Recommendation Report for Planning Permission

REF NO: BN/151/20/PL

LOCATION: Land at rear of Poachers
Eastergate Lane
Eastergate
PO20 3SJ

PROPOSAL: Erection of 1 No. 4 bedroom detached dwelling with detached carport (resubmission following BN/46/20/PL). This site is in CIL Zone 3 & is CIL Liable as new dwelling & is a Departure from the Development Plan.

FRONT (SOUTH) ELEVATION

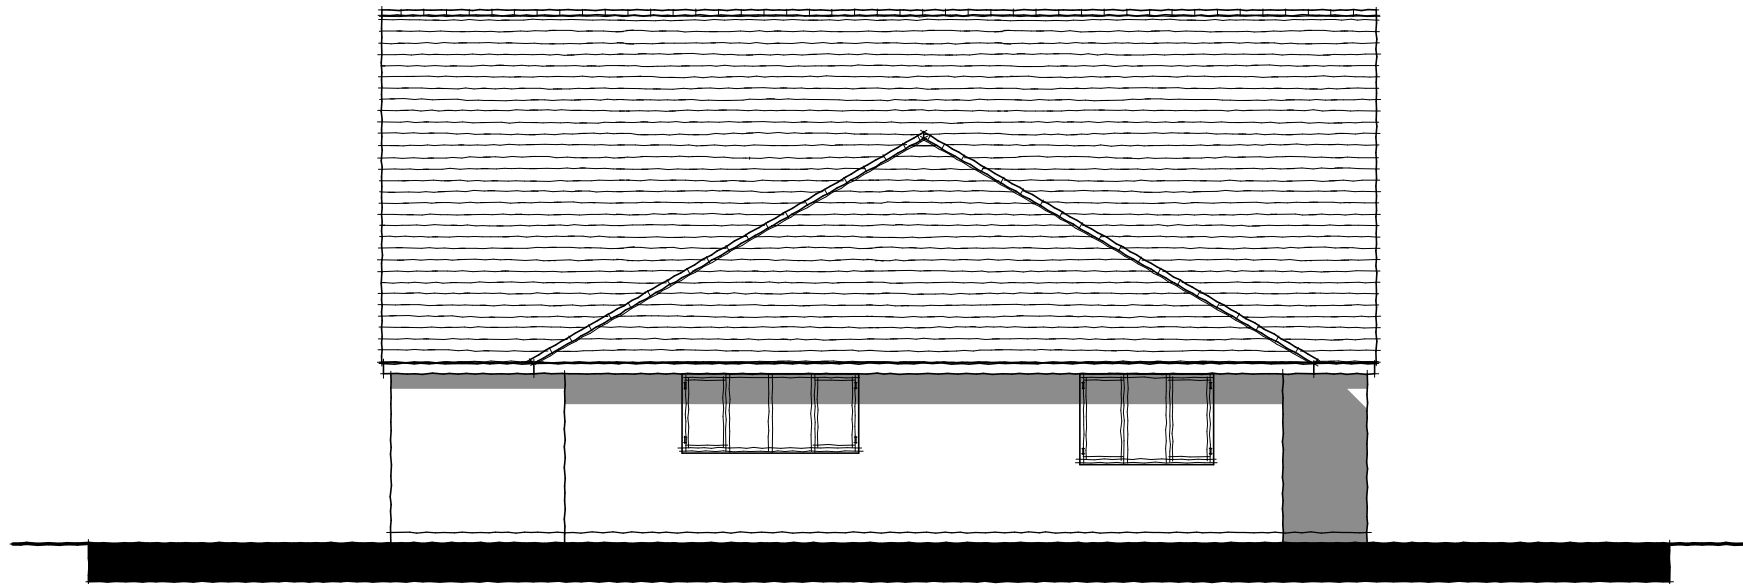
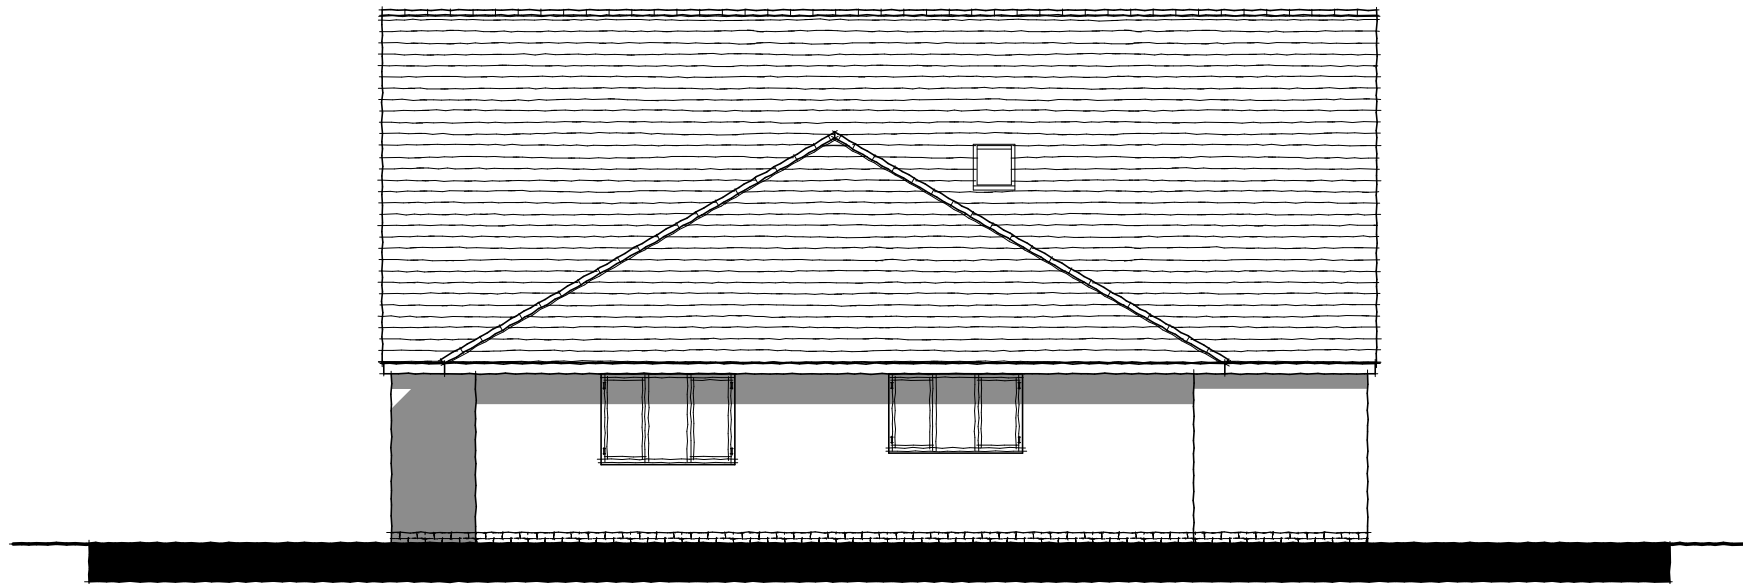
The dwelling would comprise a chalet style two storey dwelling with two significant gable elements. This would be combined with a tall ridge height and low eaves height. Whilst the elevation with two gable elements dominating the southern elevation would be readily visible from the west as well and would be in visual contrast to this rural, undeveloped nature. The proposed substantial dwelling, albeit chalet style of a significant size within a rear garden would have a significantly greater visual impact in this countryside location and would be detrimental to the open character and appearance of the area, particularly viewing from A29. The existing and proposed vegetation to the south-west and west would provide some screening of the proposed dwelling. However, there would be little to prevent the overgrown bushes, trees and the hedge being reduced in height in the future which would increase the visibility and prominence of the building and would emphasise the loss of part of the open space between sporadic properties and would harm its immediate setting. A new dwelling would generally have different characteristics, including the creation of a separate curtilage and the generation of its own domestic paraphernalia. Although the Framework does not prevent development on garden land in principle, it does require new developments to respond to local character and history and to reflect the identity of local surroundings (paragraph122).

TREE PROTECTION PLAN

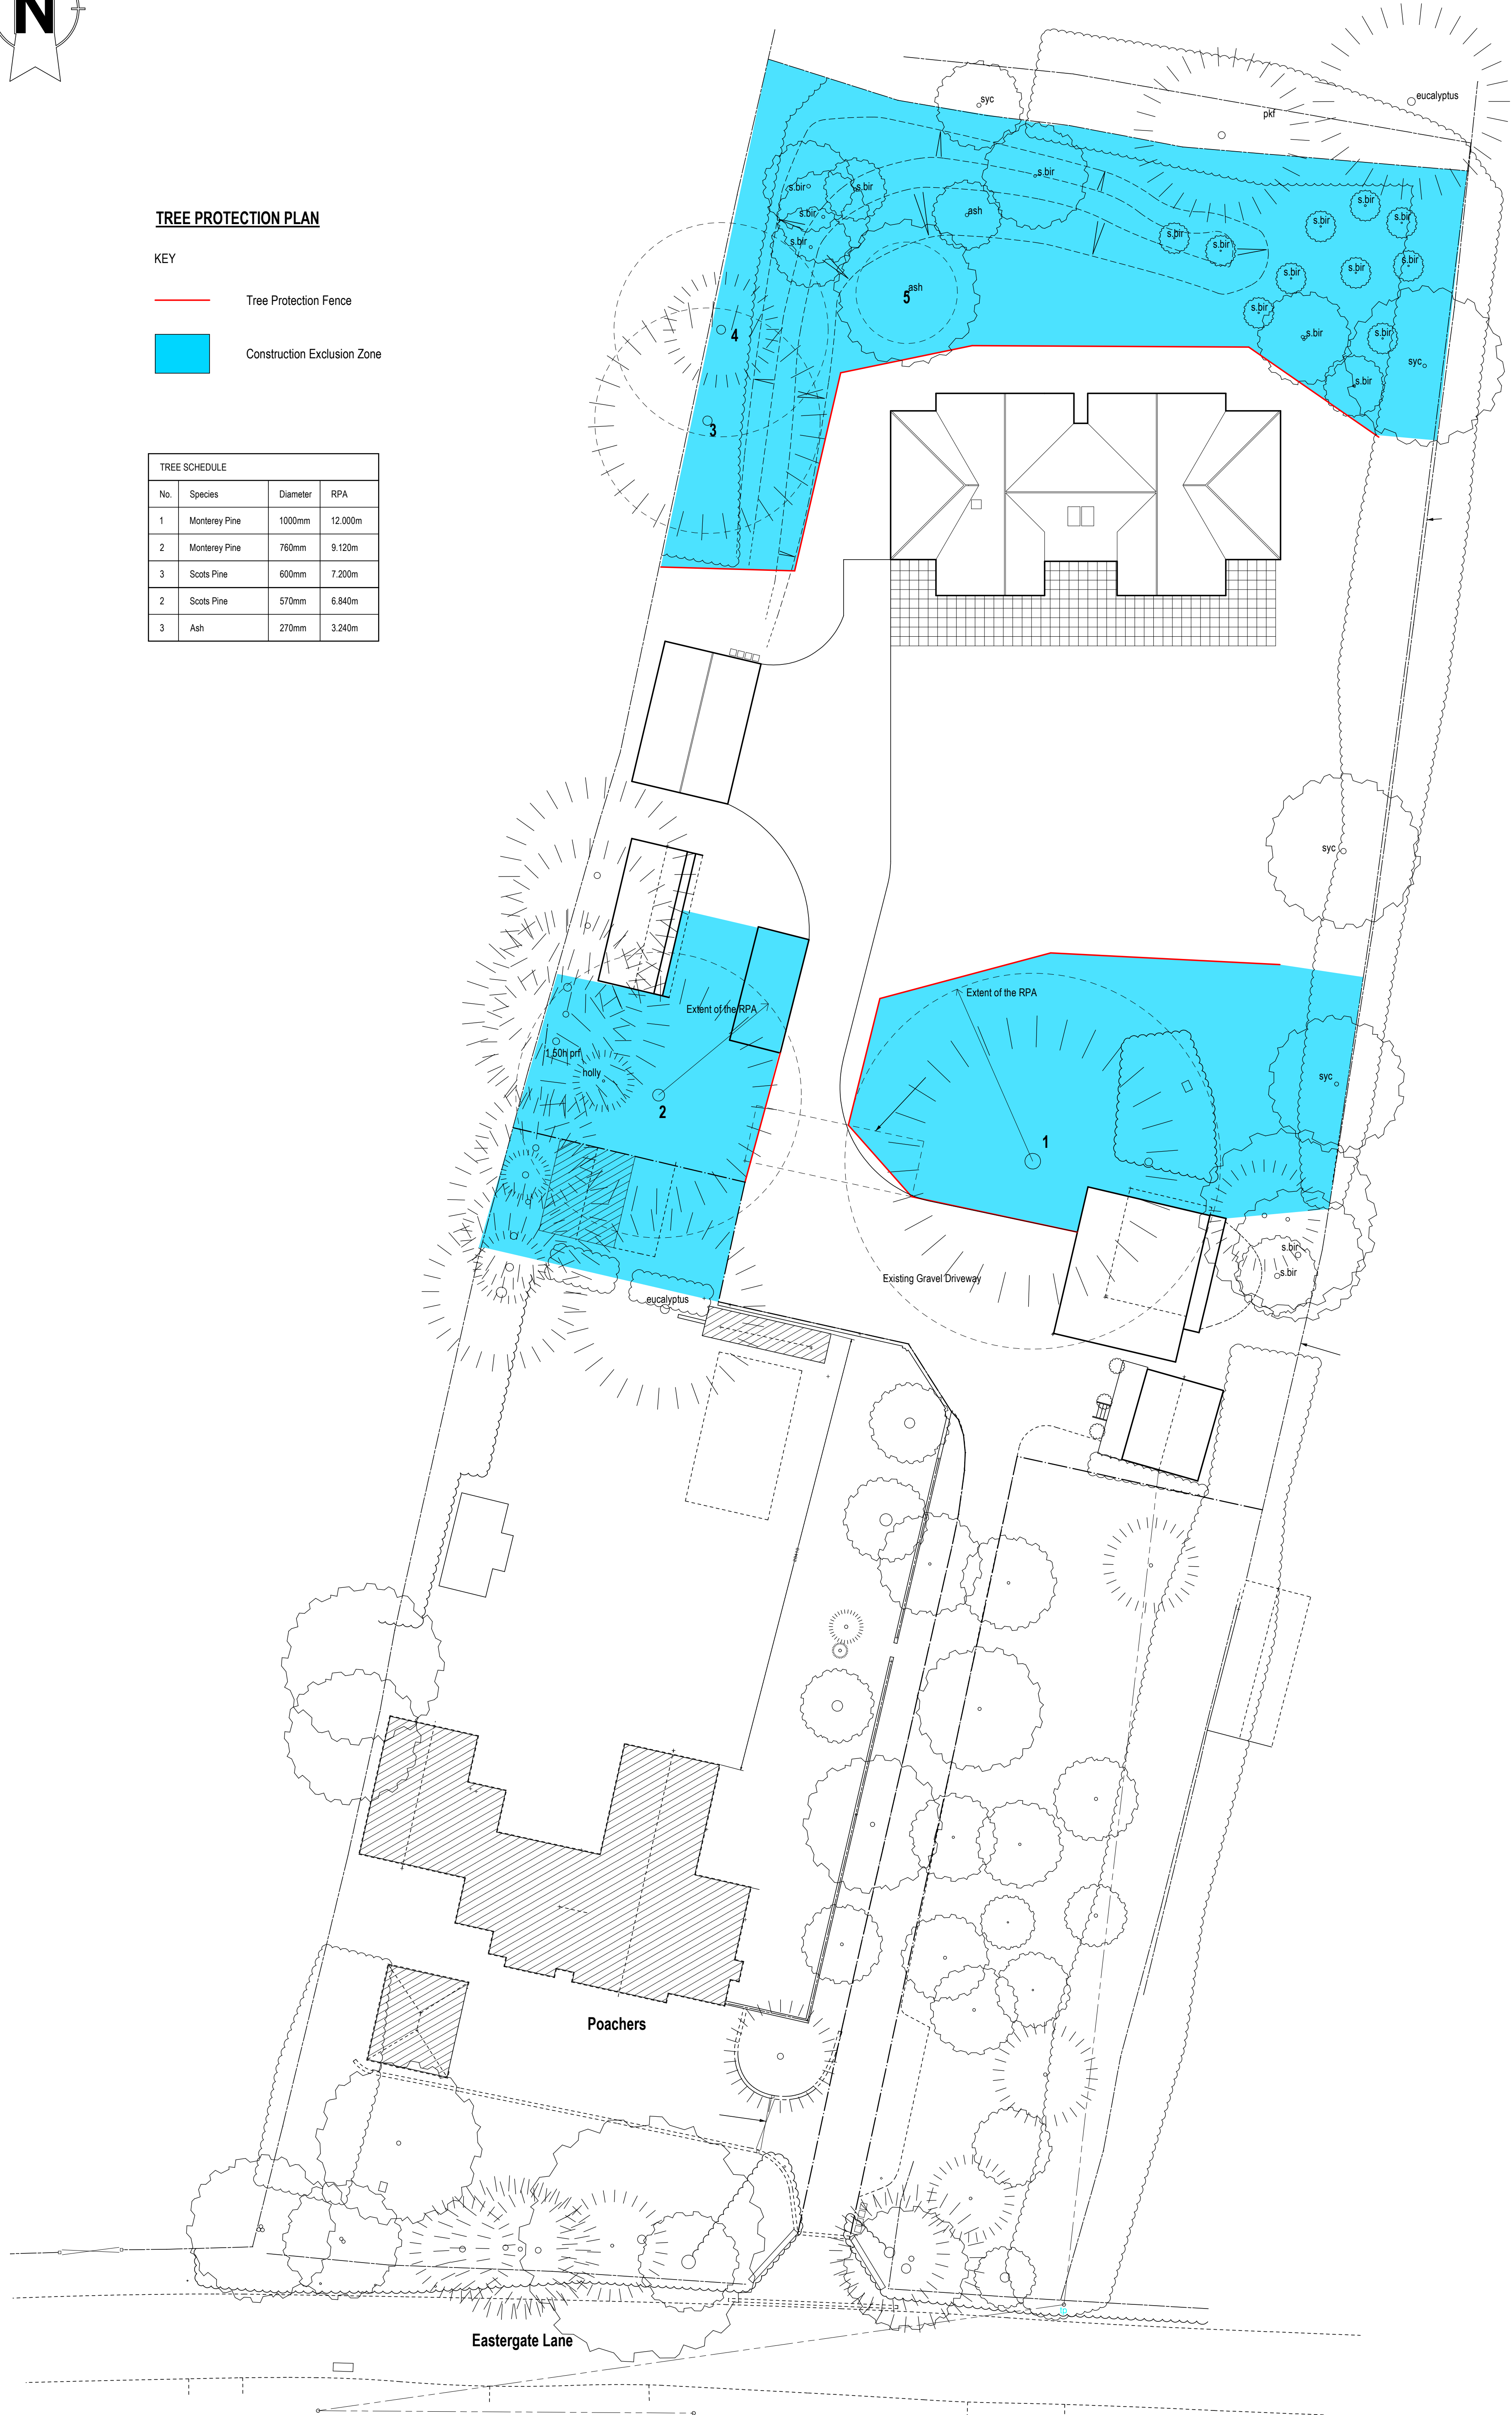
There is a significant and substantial amount of tree planting around the site at present. The submitted plans indicate the use of a Construction Exclusion Zone to protect the trees on the boundaries throughout the construction phases. However, such zones will not protect the trees and boundary landscaping in perpetuity. Therefore, a condition will be imposed requiring a landscaping scheme to be submitted prior to the occupation of the dwelling. Once agreed the landscaping scheme shall be undertaken in accordance with these details and maintained for a period of 5 years thereafter. Such a condition conforms with the tests for conditions outlined in paragraph 56 of the NPPF.

PROPOSED SITE PLAN

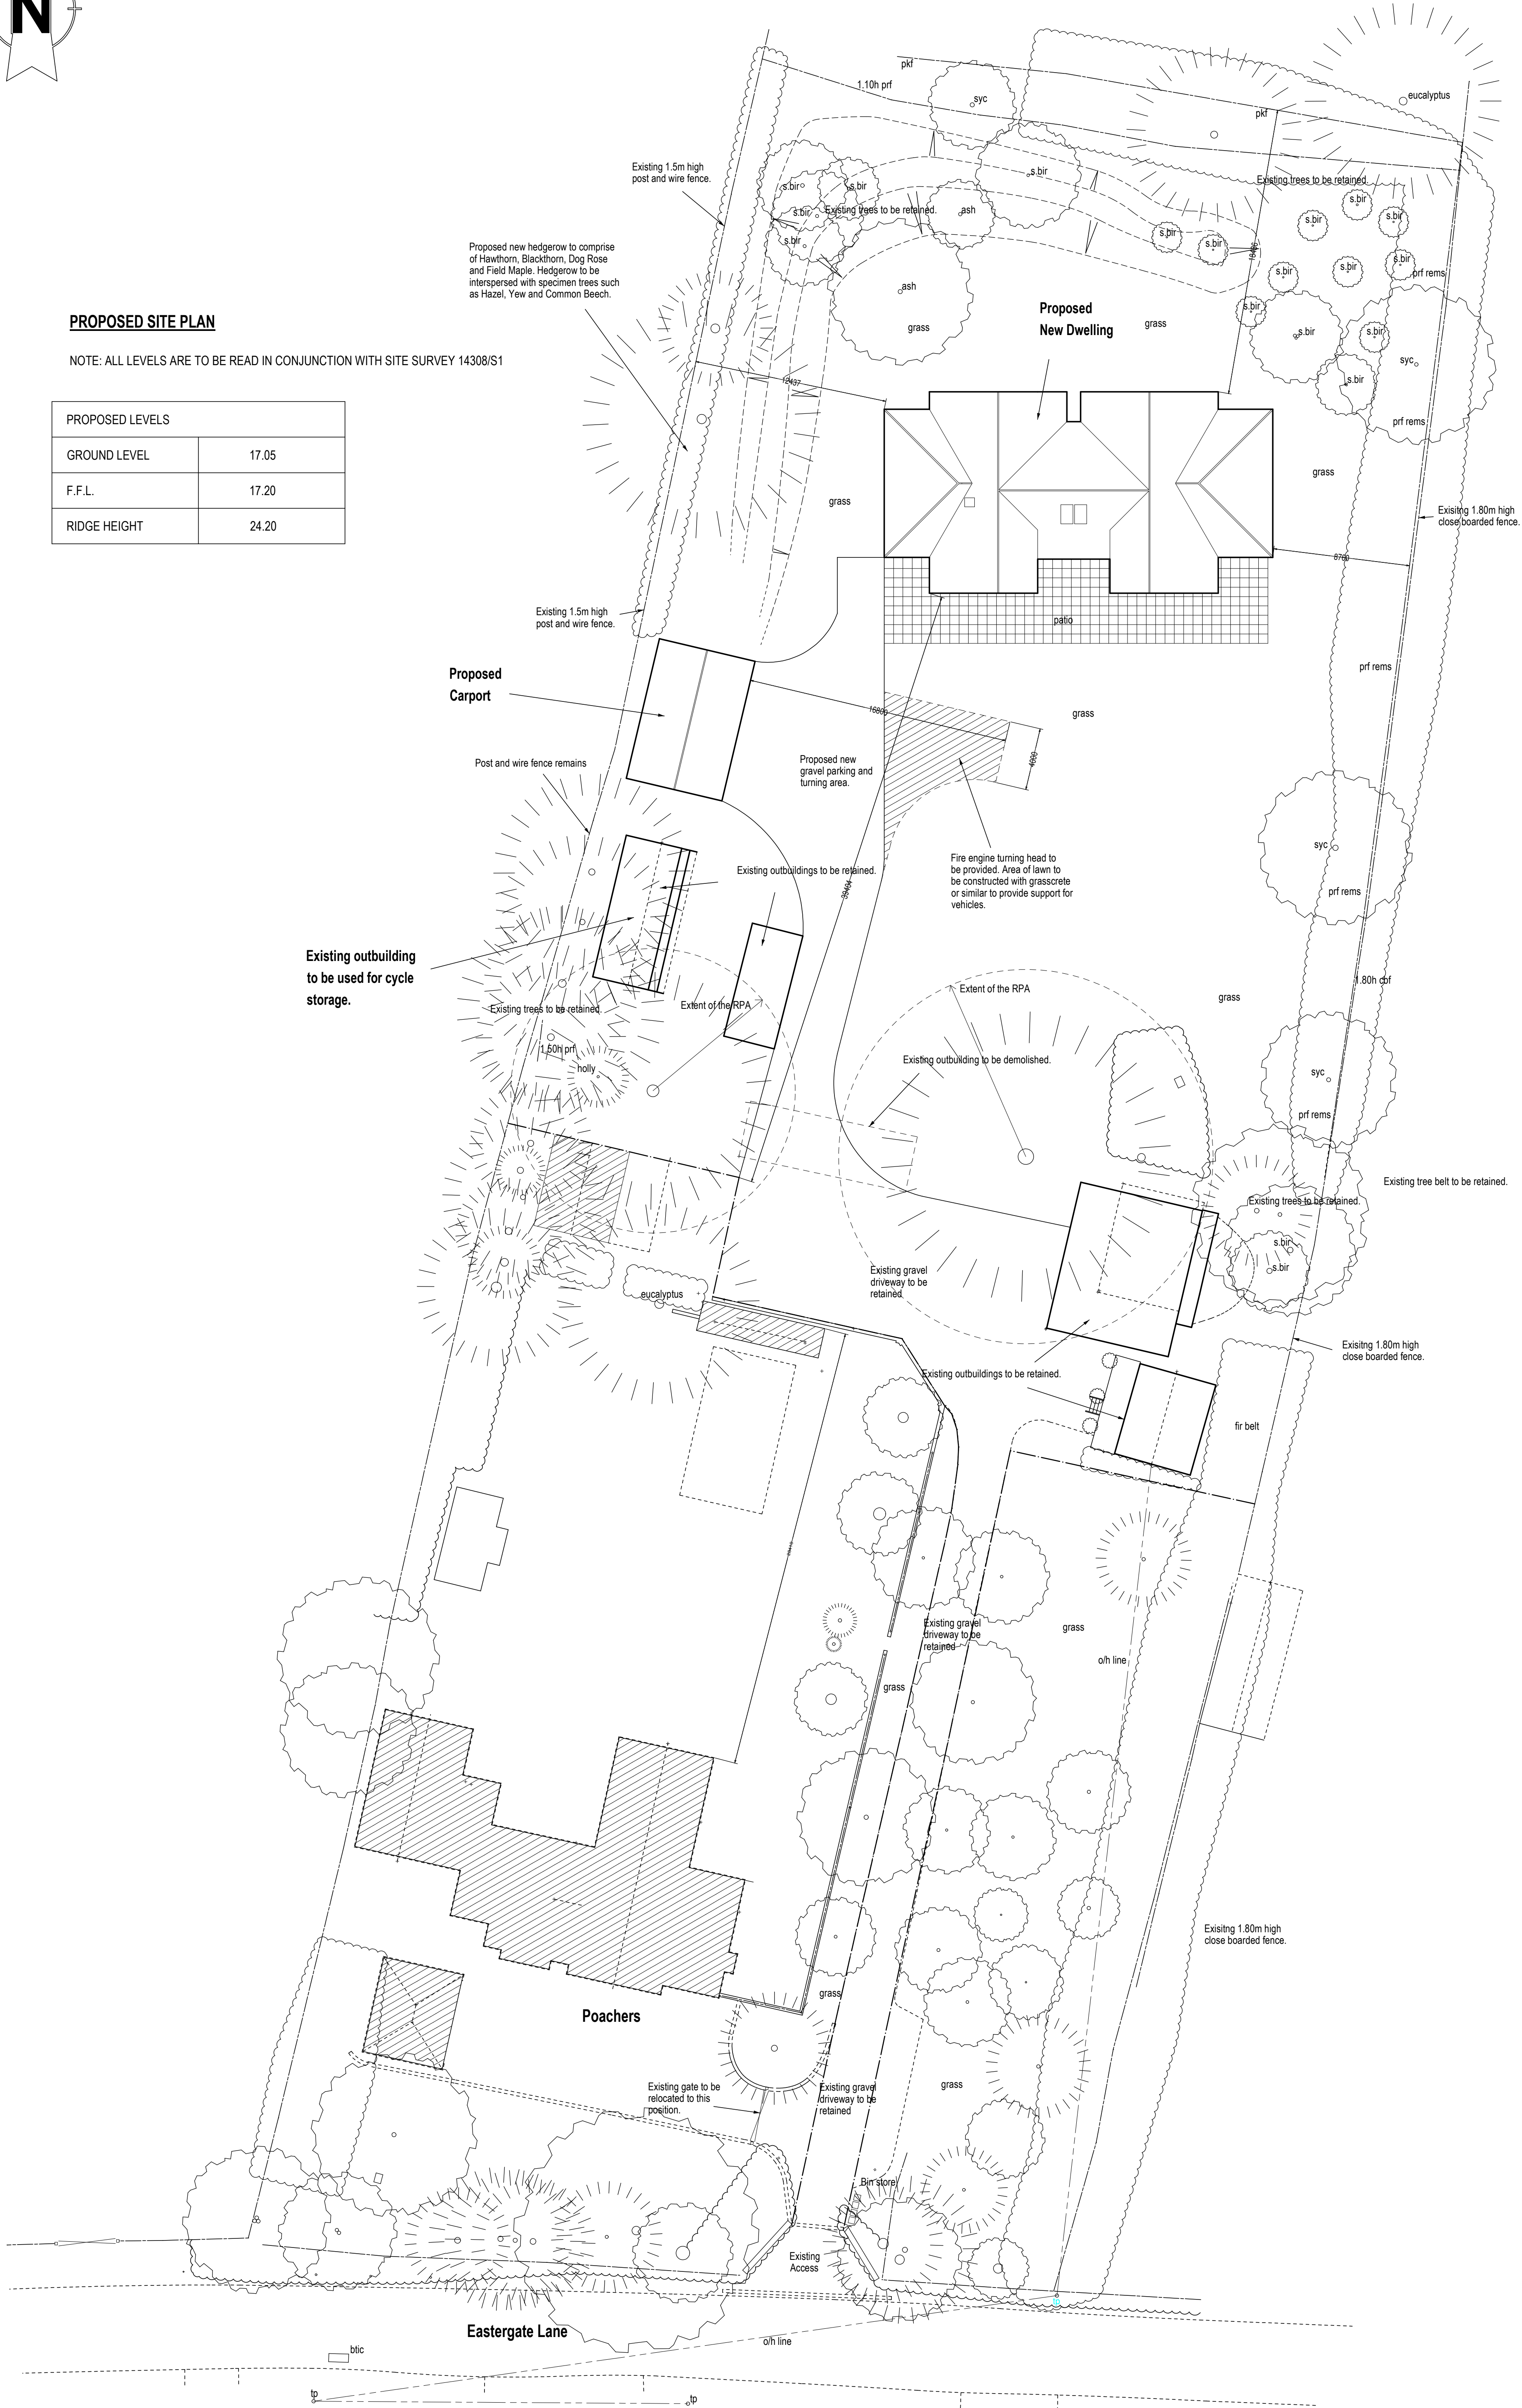
An outbuilding has been marked as the location of a cycle store on the Site Plan. The imposition of a condition requiring details to be agreed with the Local Planning Authority prior to occupation of the dwelling would address this concern raised by the Local Highways Authority.

The proposed site plan shows an area towards the southern portion of the access road which safeguards an area for bin storage. However, this specifies its use as bin storage. This area is located less than 30m from the kerbside which would allow for a drive-by collection. This form of collection is comparable to all other properties along Eastergate Lane.
